EL PASO COUNTY STORMWATER MANAGEMENT PLAN CHECKLIST

EPC Project Number: PPR-22-017

**CLEARVIEW CONVENIENCE STORE
 GRADING, EROSION, AND SEDIMENT CONTROL PLANS
 INITIAL & INTERIM EROSION CONTROL PLAN**

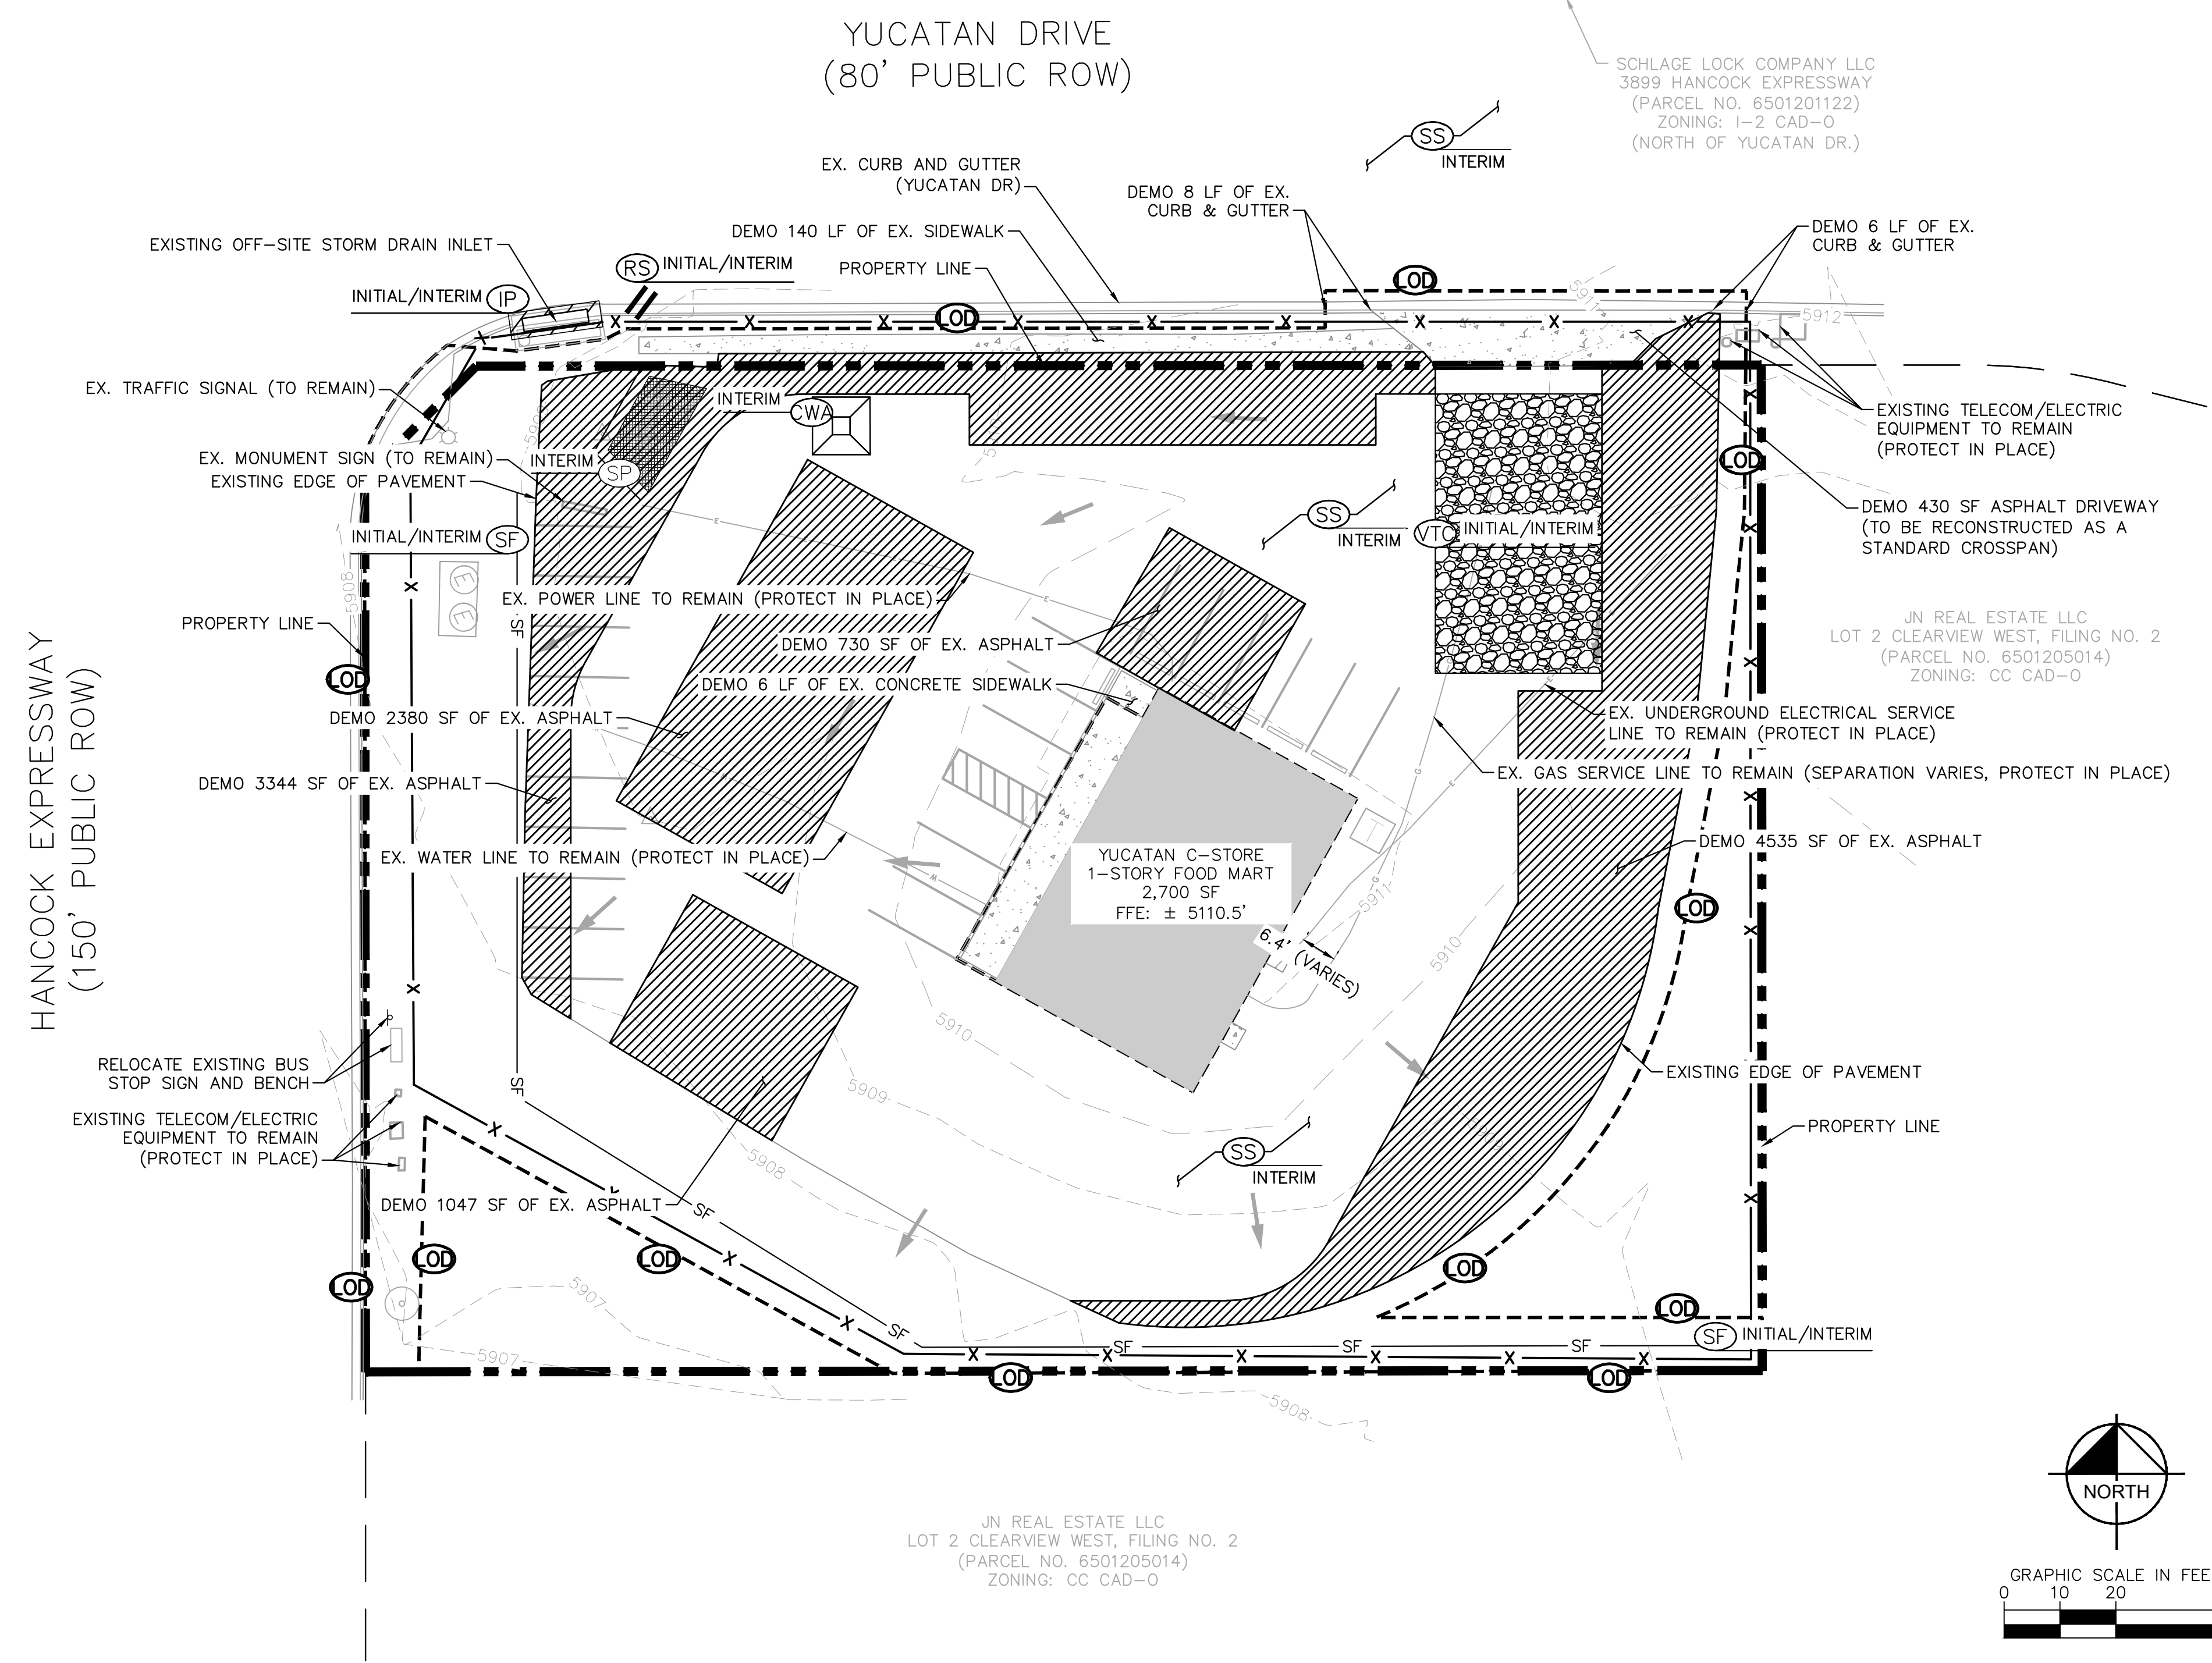
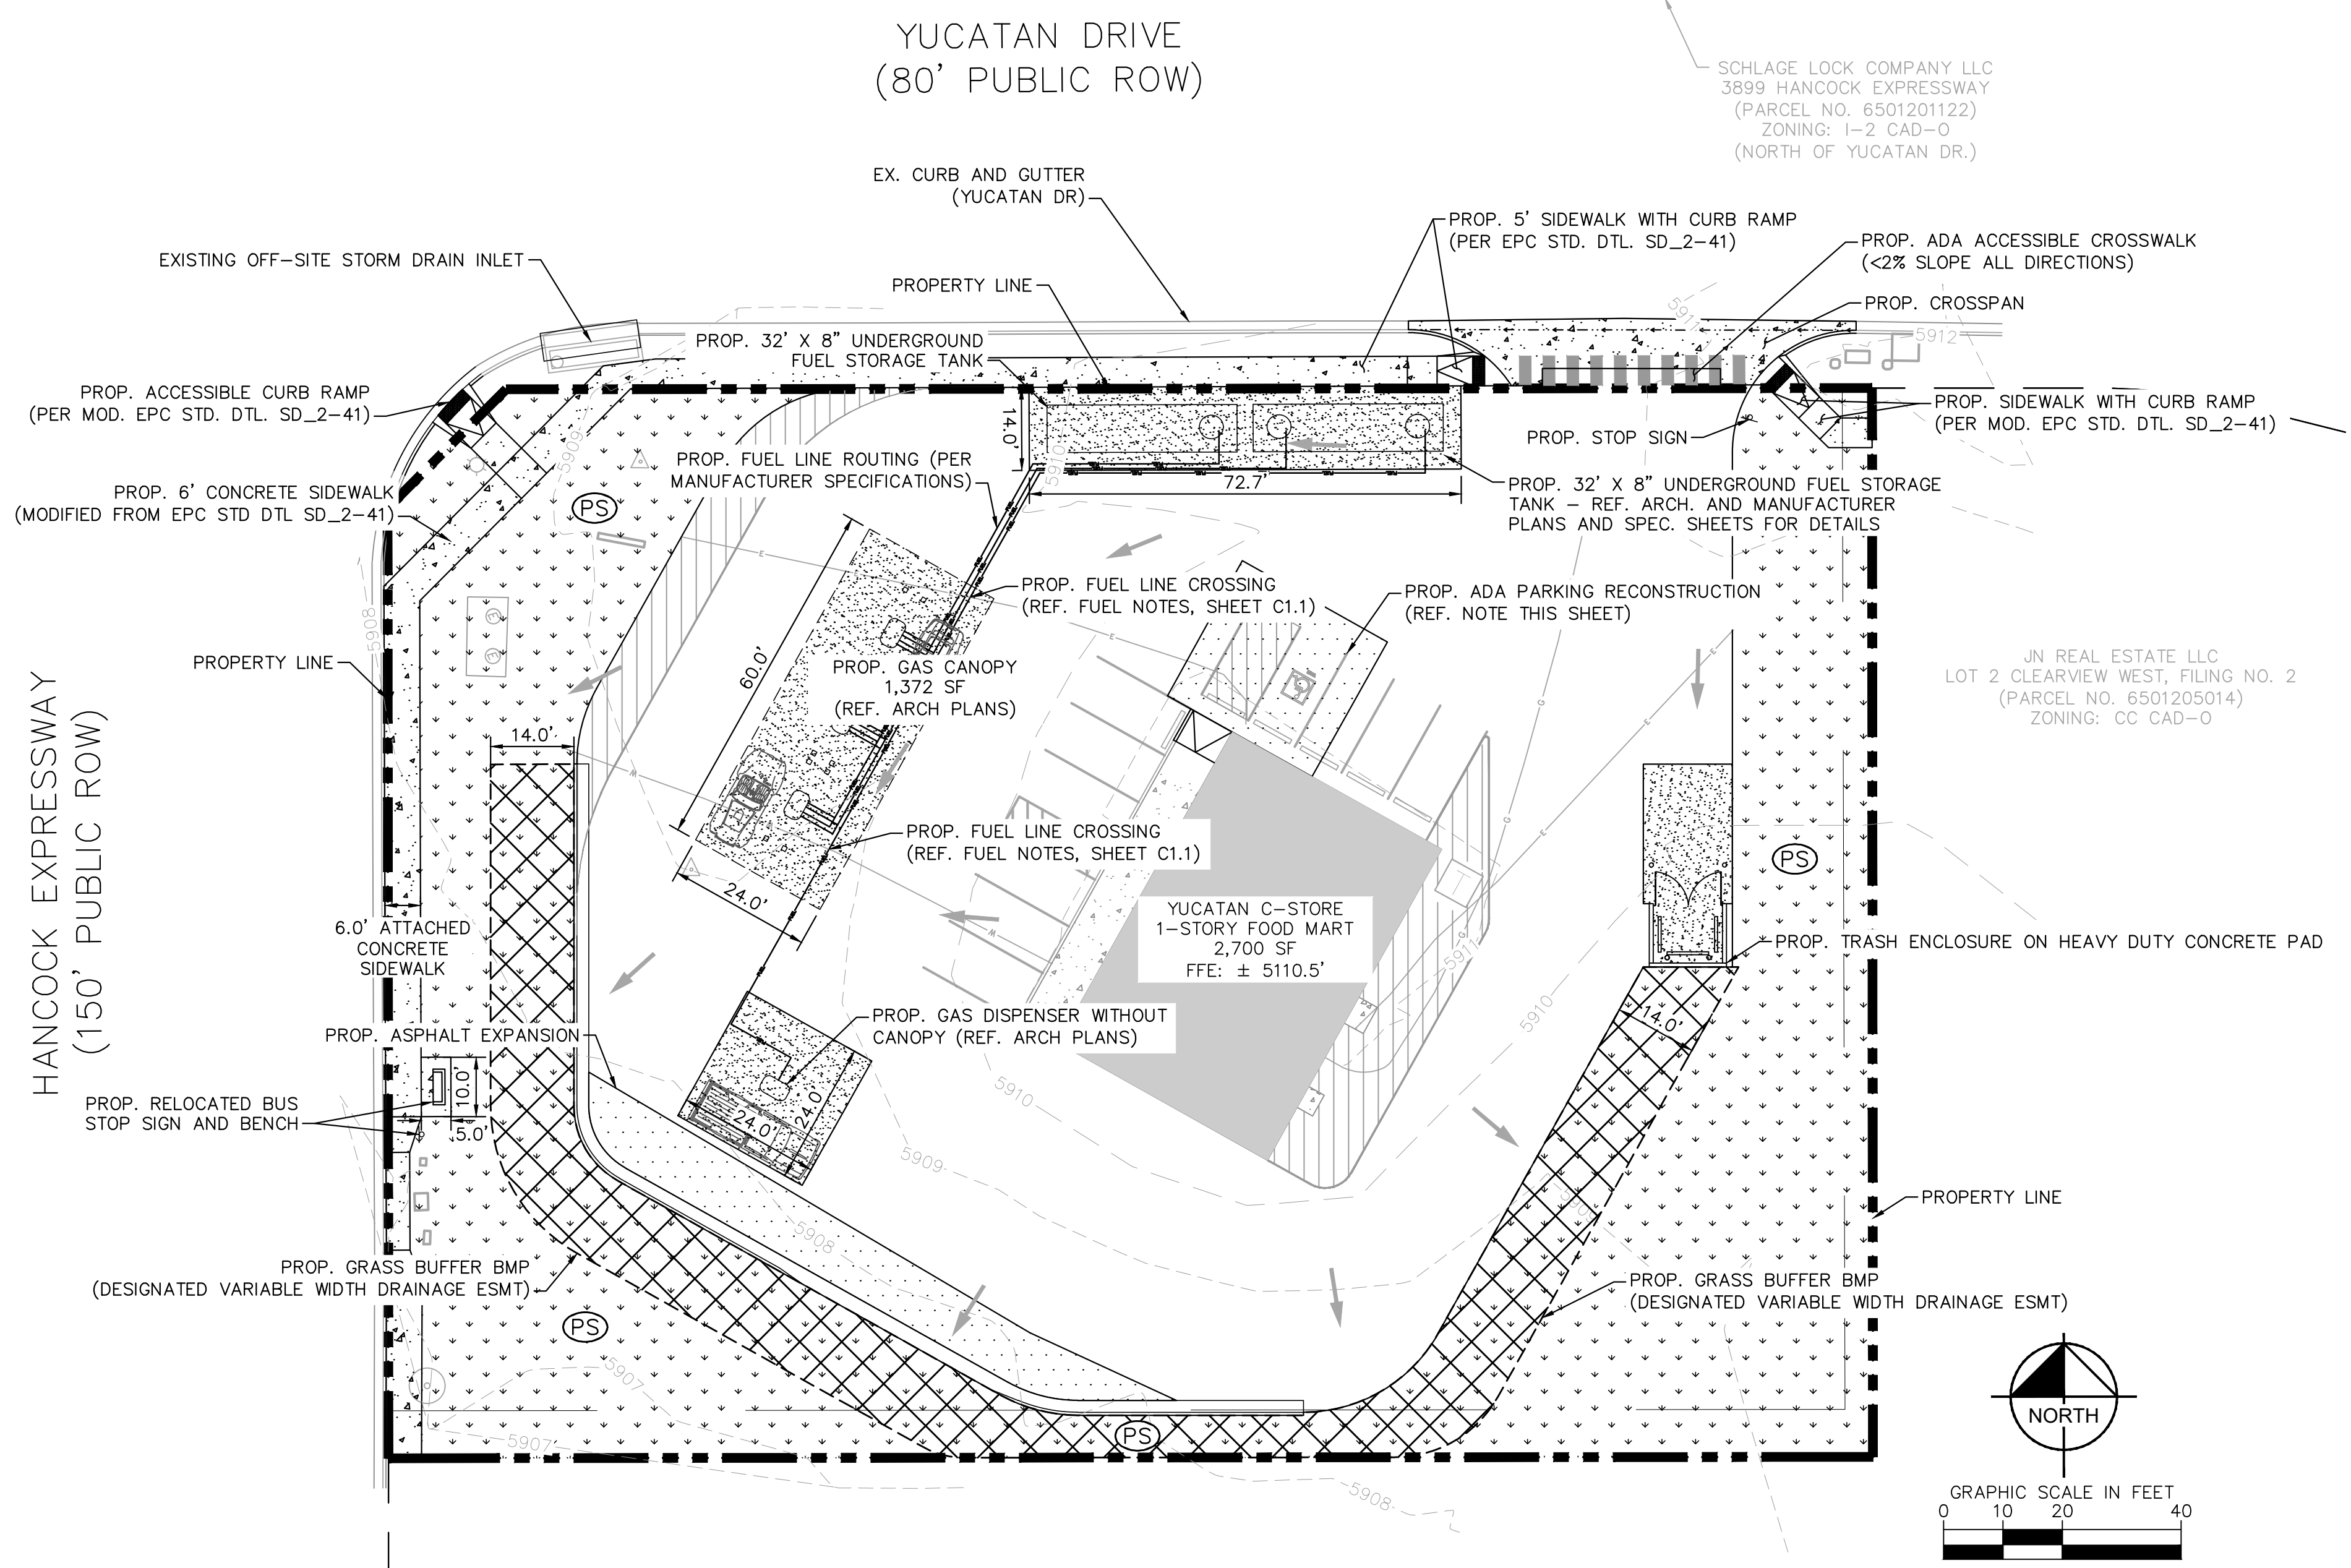
| | | Applicant | EPC |
|--|---|-----------|-----|
| 17a | construction site boundaries | | ✗ |
| 17c | all areas of disturbance | | ✗ |
| 17d | areas of cut and fill | | ✗ |
| 17f | location of any dedicated asphalt / concrete batch plants add note to GEC Not used on site. | ✓ | ✗ |
| 17i | springs, streams, wetlands and other surface waters, including areas that require maintenance of pre-existing vegetation within 50 feet of a receiving water None exist on or near the site. | ✓ | ✗ |
| 20 | Technical drawing details for all control measure installation and maintenance; custom or other jurisdiction's details used must meet or exceed EPC standards see comments on GEC | | ✗ |
